Ref: SSD-82548708

**RESPONSE TO SUBMISSIONS SSD-82548708, RESIDENTIAL FLAT BUILDING WITH
INFILL - 24, 26 & 28 MIDDLE HARBOUR ROAD, LINDFIELD**

Attachment 1 - Ku-ring-gai Council's Response to Applicant's RTS

Drawing Name
Deep Soil Diagrams

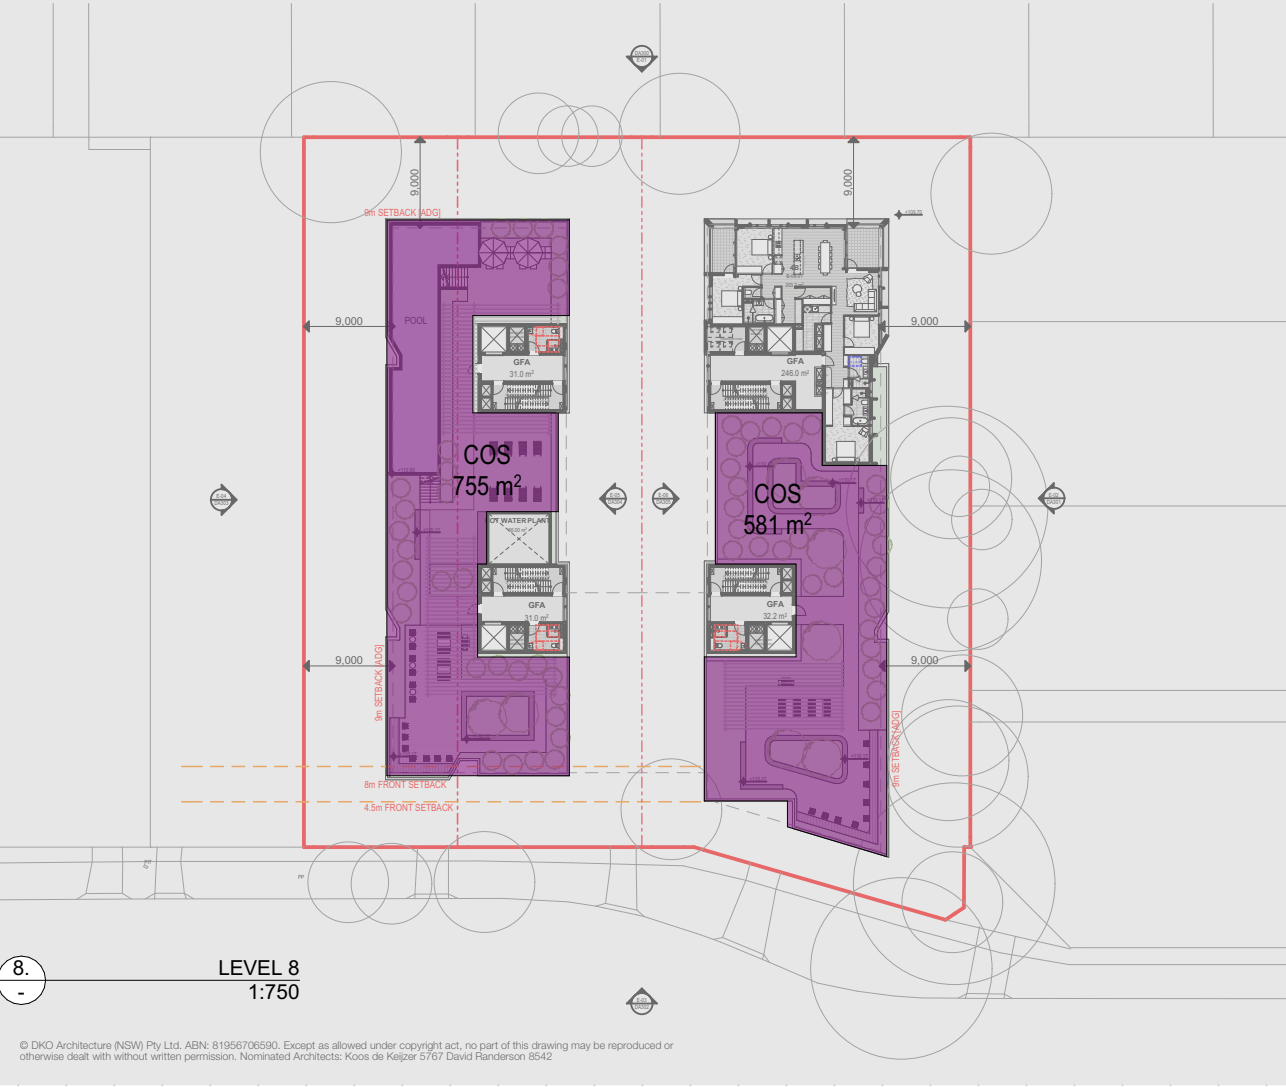
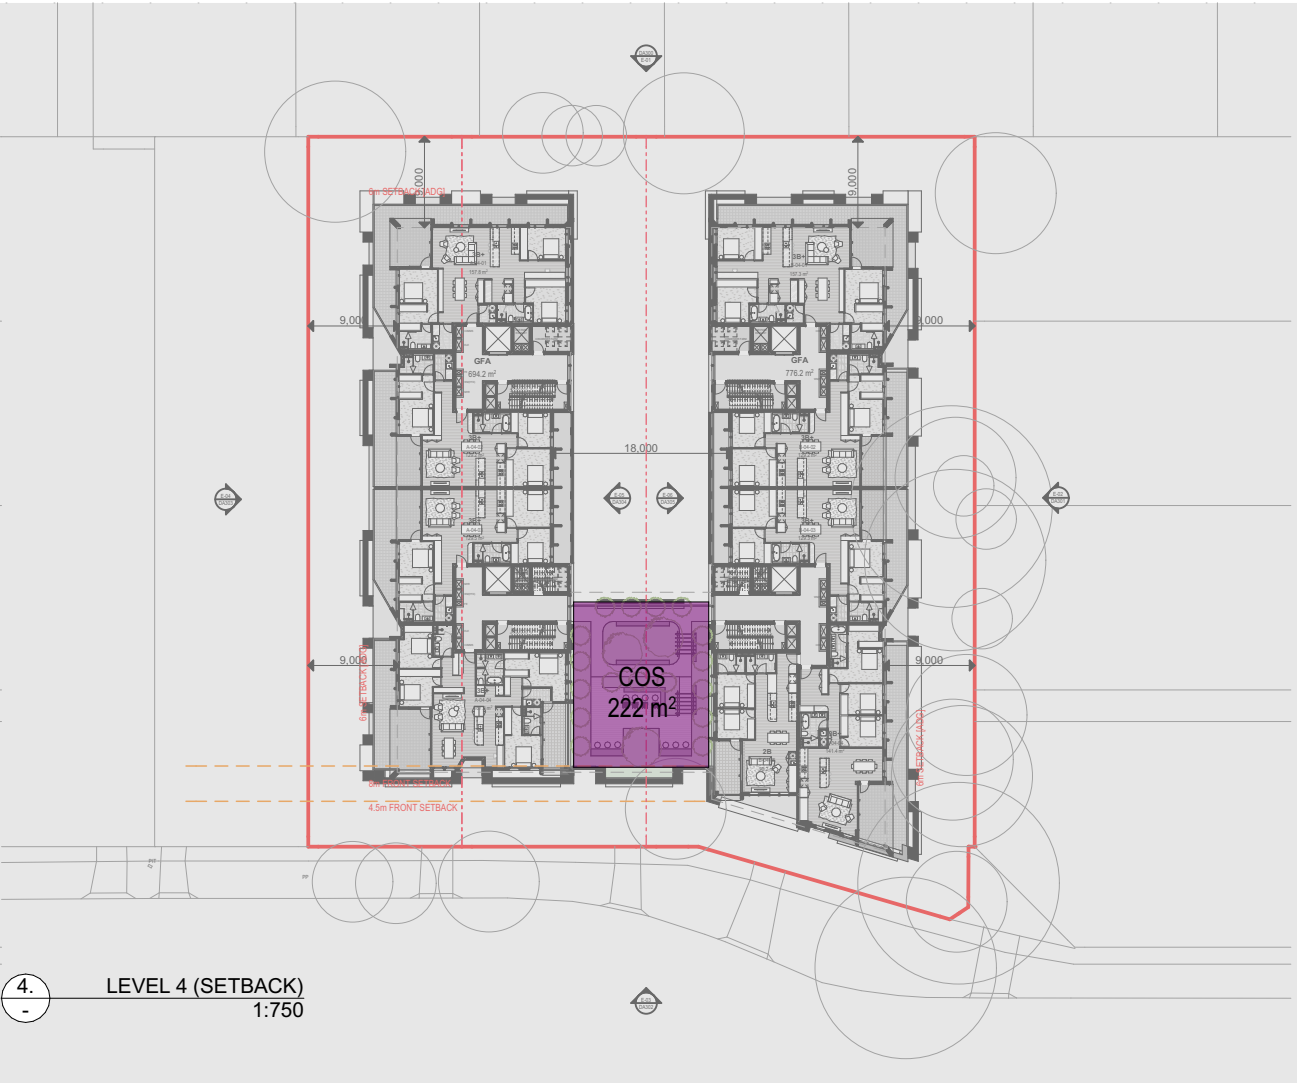
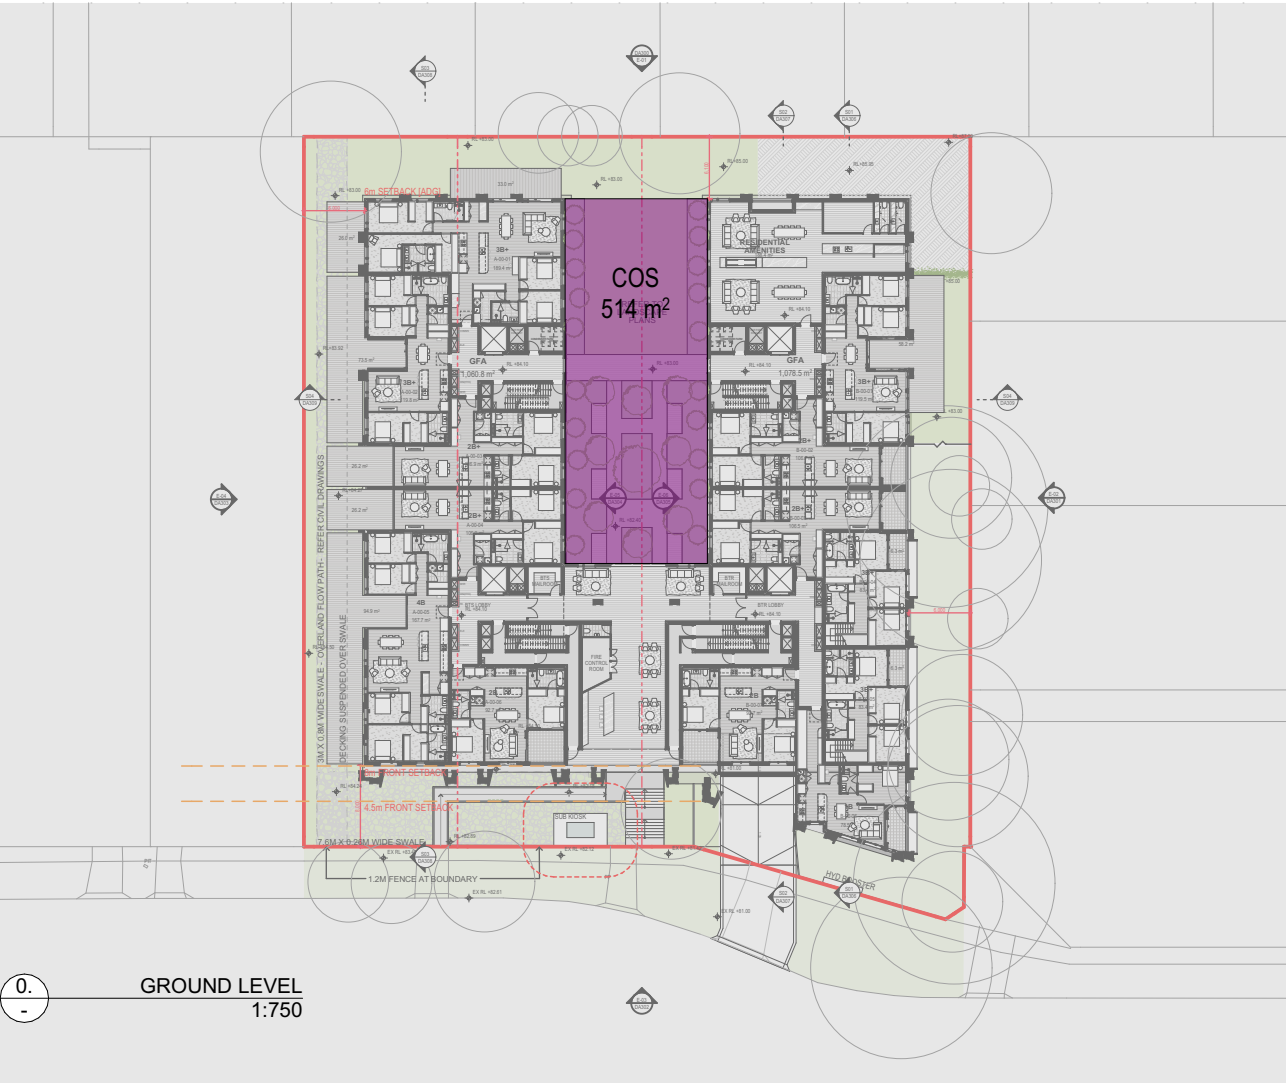
The submitted landscape area compliance plan is inconsistent with the SEPP definition and includes landscape site area that is occupied by the building.
Insufficient Deep Soil zones	Unresolved. Part 3E Deep soil zones Deep soil zone is defined as ‘areas of soil not covered by buildings or structures within a development. They exclude basement car parks, services, swimming pools, tennis courts and impervious surfaces including car parks, driveways and roof areas’. For sites greater than 1500sqm a minimum dimension of 6.0m is required by the ADG Objective 3E-1 Design criteria 1. Due to the sites context and established treed landscape character, it is assessed that as the site area of 4757m² is significantly larger than 1500m² the ADG design guidance of 15% deep soil should apply as a minimum. 15% site area equates to 713.5sqm. The applicants deep soil compliance plan and calculable areas incorrectly includes areas that are inconsistent with the definition including: • The perimeter areas that do not meet the minimum 6.0m dimension. • Impervious surfaces • Services eg 525mm drainage line within the western setback and street frontage. It is assessed that the development will result in a deep soil zone of only 407m² or 8% of the site area and is inconsistent with the ADG requirements failing to meet the 15% deep soil zone design criteria objective. The lack of deep soil zones within site setbacks is inconsistent with ‘Greener Places’ design opportunities for viable supplementary tall tree plantings consistent with the established landscape character and streetscape. The applicant's justifications for lack of deep soil zones, consistent with the ADG definition is not accepted.
